## **Response to Planning Application**

**From:** Arun District Council Greenspace

**Application ref:** P/49/21/RES

**Location:** Land North of Sefter Road & 80 Rose Green Road Pagham

Drawing No CSA/2038/126

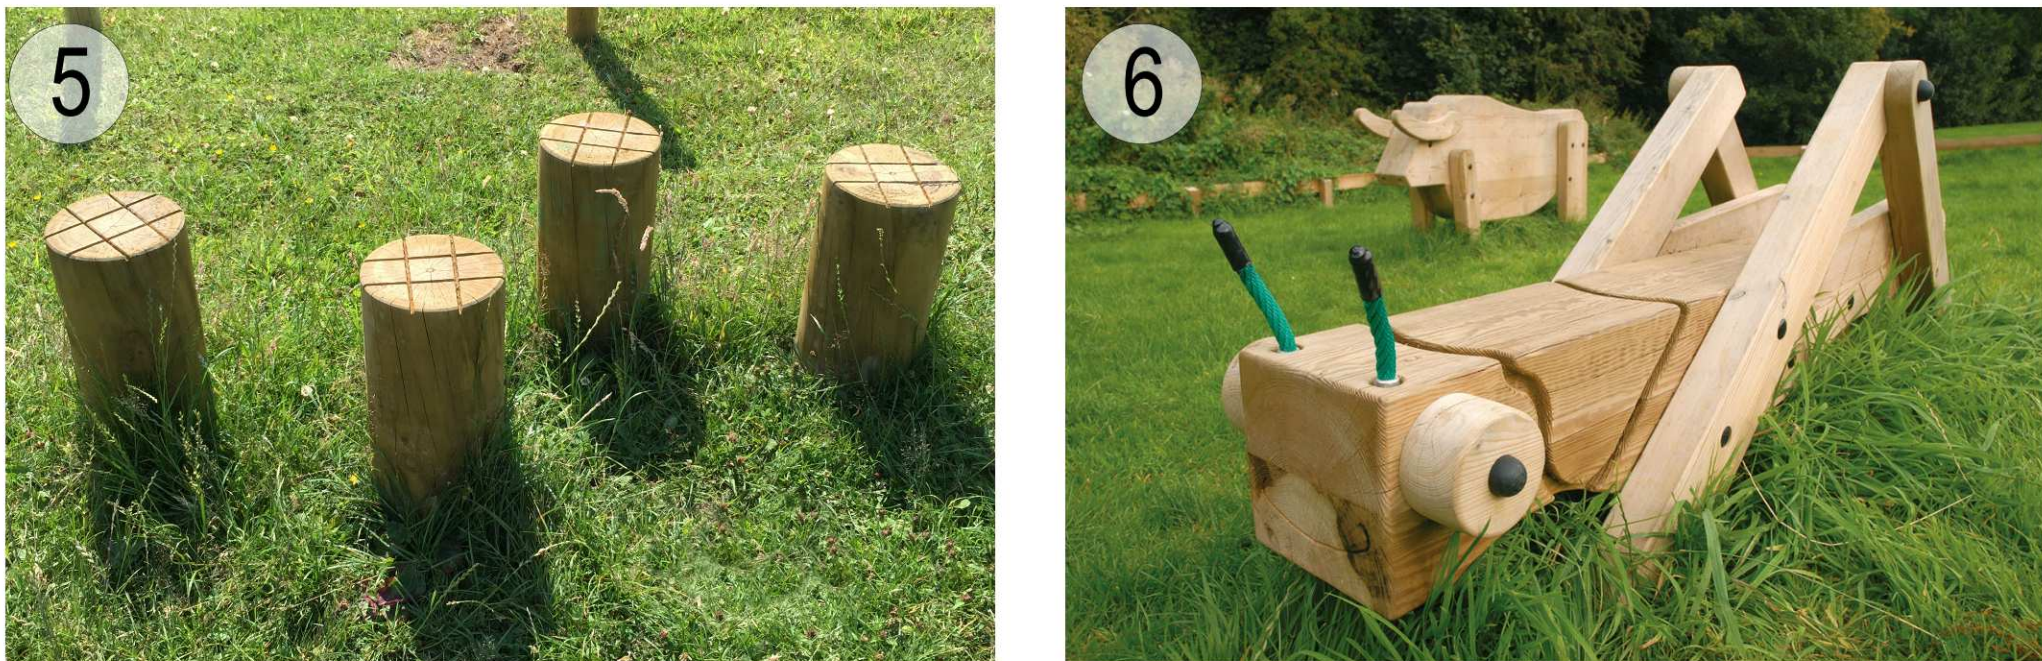
Previous consultation and 106 agreement had concluded in a requirement for an enhanced ELEAP catering for a minimum 8 play experiences and for there to be several LAPs located within the site. These are now shown and detailed within POS Dwgs CSA/2038/124 Rev B – LAP 1, CSA/2038/126 Rev B – LAPs 2&3, CSA/2038/128 Rev B – LAP 4. These LAPs appear to be well thought out, contain a good range of informal play and will be a valuable asset within the development. Detail has also been provided re the provision of the ELEAP within Dwg CSA/2038/139 ELEAP Playground Proposals. This detail has proposed a good play area offer containing equipment choice, surfacing, fencing and connectivity to the pathway network for the formal play.

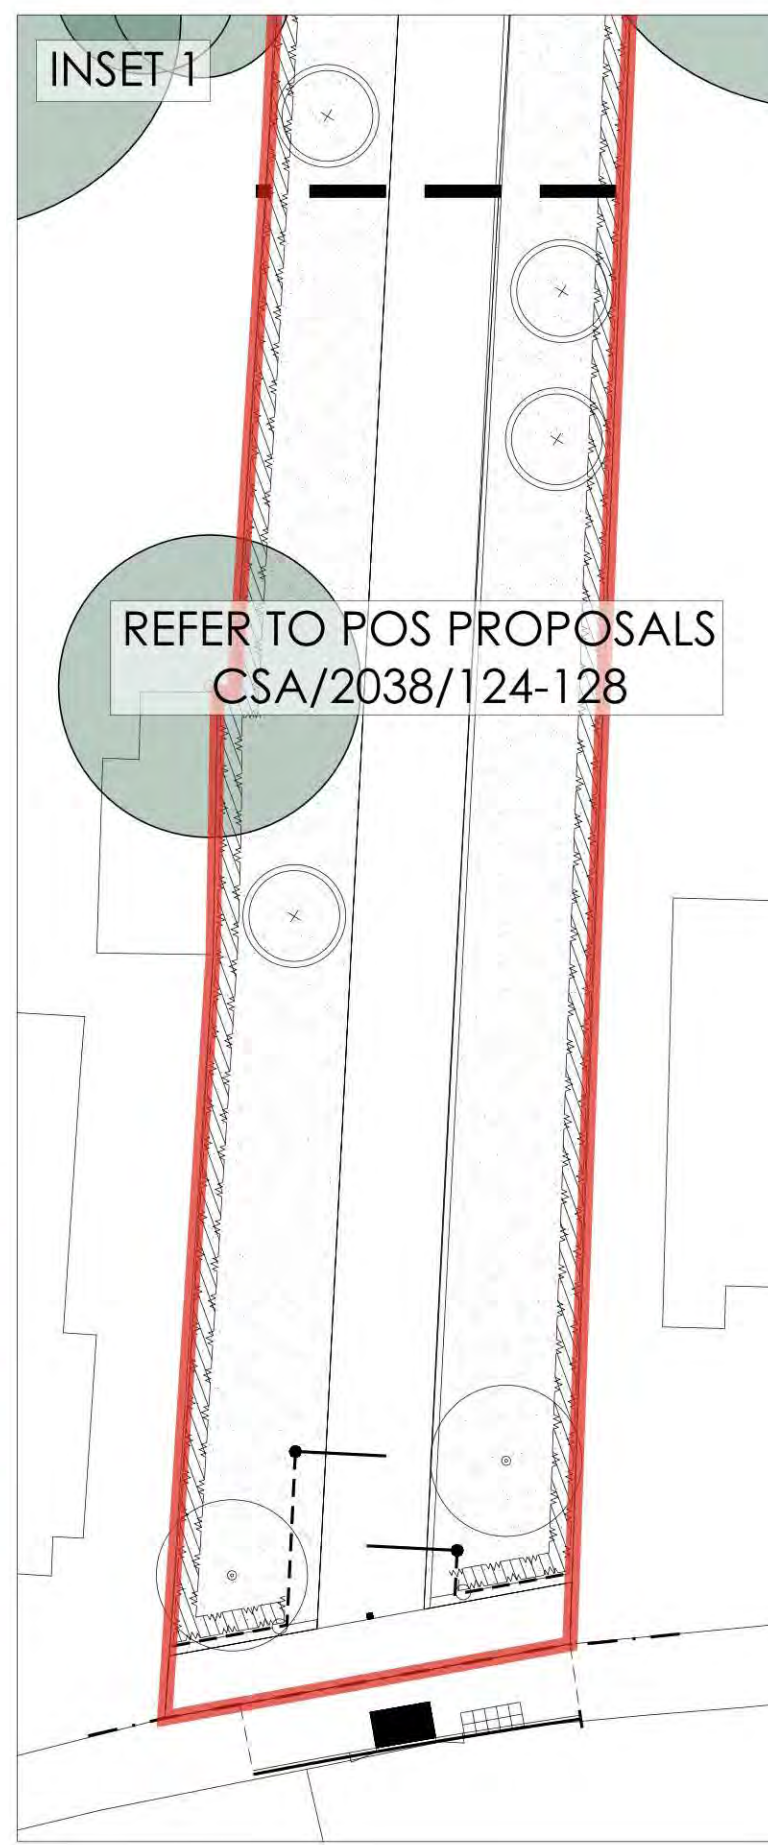
The submission of detailed information contained in the POS Landscape Proposals Sheets 1-5 of 5 Dwg nos CSA/2038/129/-133 inc Rev B contain detailed POS, open areas, boundary and periphery buffer

Soft landscaping has now been shown to the plot areas with the inclusion of a good variety of trees and shrubs to aid in the creation of sense of place, and the encouragement of biodiversity habitat. The Soft Landscape Proposals sheets 1-5 of 5 Dwg nos CSA/2038/129/Rev B have now provided the on plot landscape detail which was lacking on previous applications and provides the information in sufficient detail in plan form detailing species choice, actual quantities, planting densities and size at time of planting.
